From: Charlotte Burrows
Sent: 06 February 2018 09:50
To: [REDACTED]
Subject: RE: R/14/18/T - Proposed Maintenance to TPO Tree & Bush rear garden of 12 Bushby Ave

From: G J John [REDACTED]
Sent: 30 January 2018 09:11
To: Planning
Subject: R/14/18/T - Proposed Maintenance to TPO Tree & Bush rear garden of 12 Bushby Ave

SKETCH 18.1 SITE PLAN - (EAP OF 12 BUSBY / WAVERLEY RD

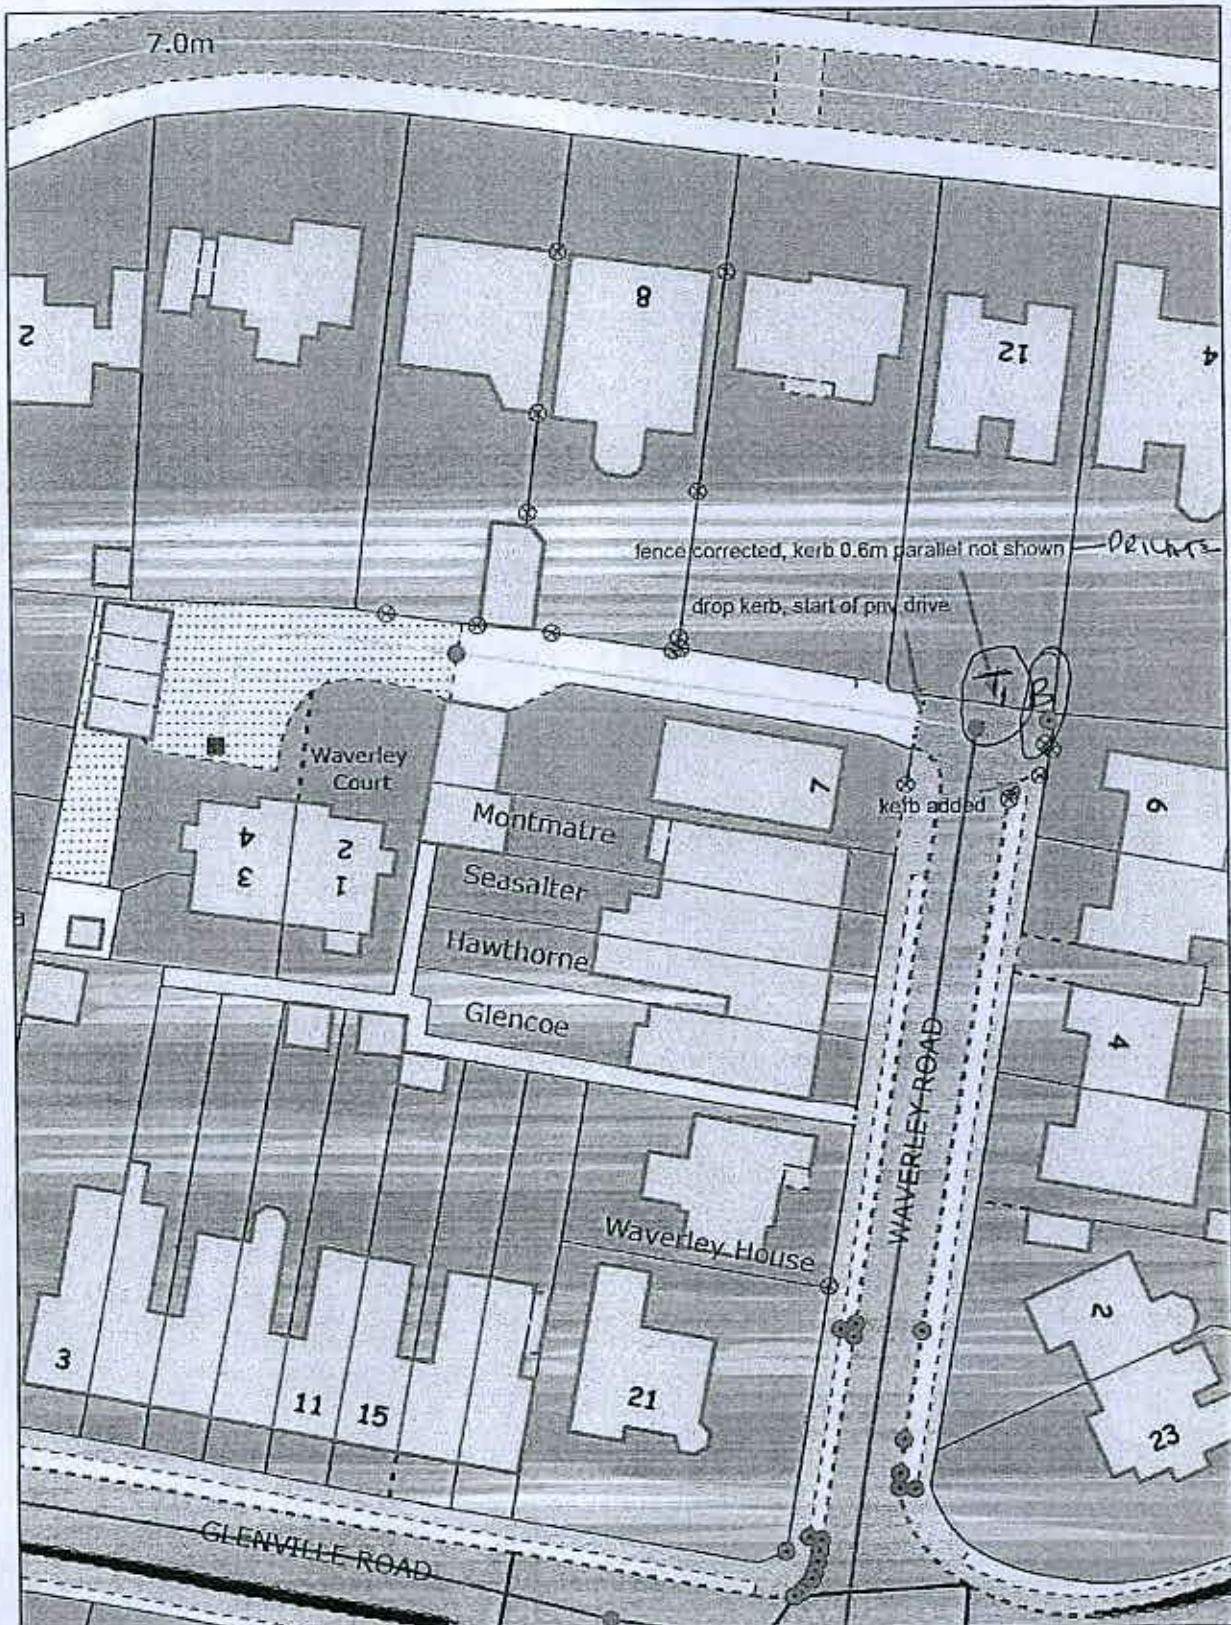
Unfortunately we will still require that you confirm the exact species of the 'bushes' as annotated as B1 to ascertain whether or not they are protected by the tree preservation order.

We would suggest you ask your tree surgeon or another professional to confirm the species if you are not sure.

1. Crown Raise the TPO tree to 5.5-6mts over the carriageway and
2. Prune back the (NON TPO) bush to the north boundary if this bush requires planning approval.

1. The TPO Tree is located inside the rear garden of 12 Bushby Ave and outside the North Boundary of Waverley Road.

2. The Garden Bush is overhanging the boundary is located adjacent to the TPO tree.
